**WELWYN HATFIELD BOROUGH COUNCIL  
ASSISTANT DIRECTOR (PLANNING)**

**Application No:** 6/2023/2032/LAWP  
**Location:** 81 Bramble Road Hatfield AL10 9SB  
**Proposal:** Certificate of lawfulness for a loft conversion with hip to gable extension and rear dormer  
**Officer:** Mrs Kerrie Charles

**Recommendation:** Refused

EXISTING ROOF PLAN

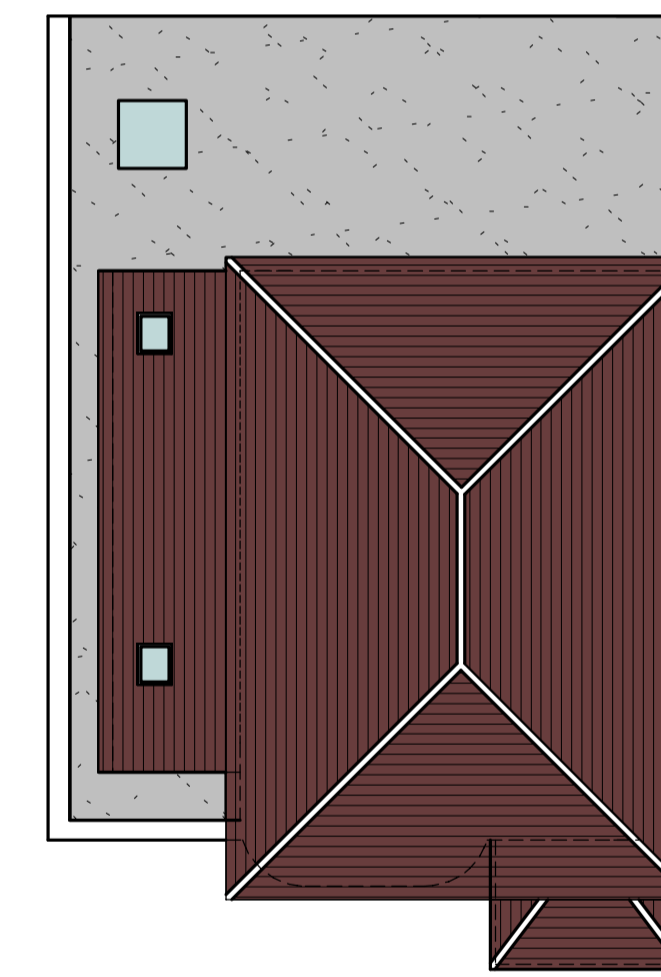
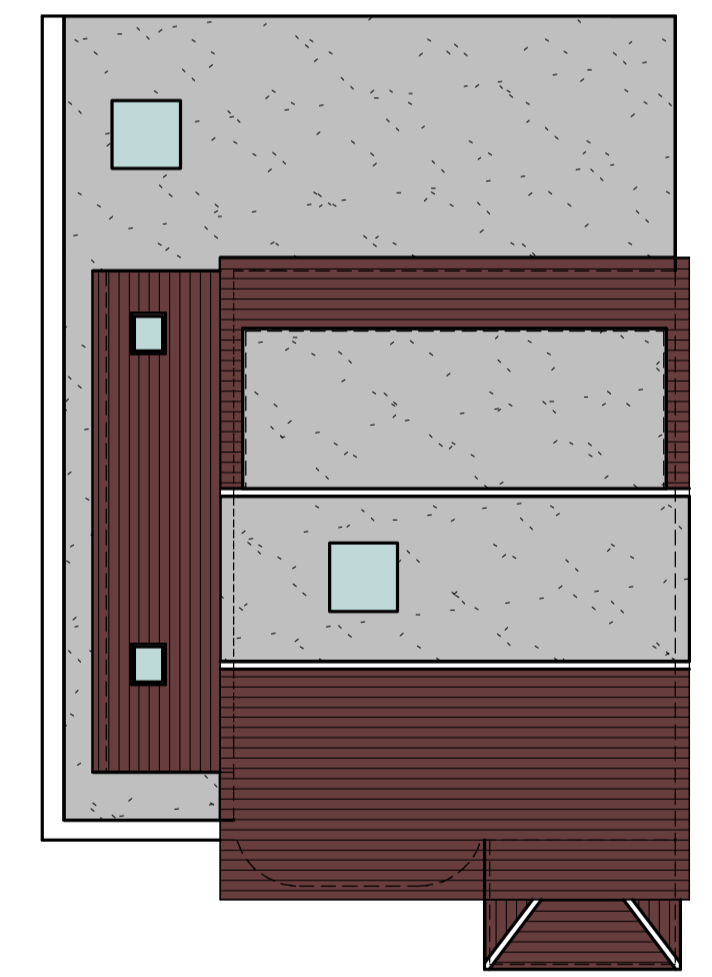
The existing roof is hipped on all four sides with a ridge running front to back. The proposal would see both side hips replaced with gable walls and the creation of a flat crown roof between the new side to side ridgelines. A large flat roofed dormer is proposed to the rear, occupying almost the entire width of the roof slope.

Having regard to the details on the drawings, the works involved would be significant and, on the basis of the information submitted, would entail the removal and remodelling of most, if not all, of the roof during construction.

There are no detailed construction drawings to demonstrate the extent of what would be retained. However, having regard to the details on the drawings, it is more than likely that none of the rafters would not be retained as most of them would be lying in the wrong direction, or too short in length, to serve the new roof. As a matter of fact and degree it is considered that the proposed development would not therefore amount to either an "addition", "alteration" or "other alteration" to the roof as a substantial part of the original roof structure would not remain.
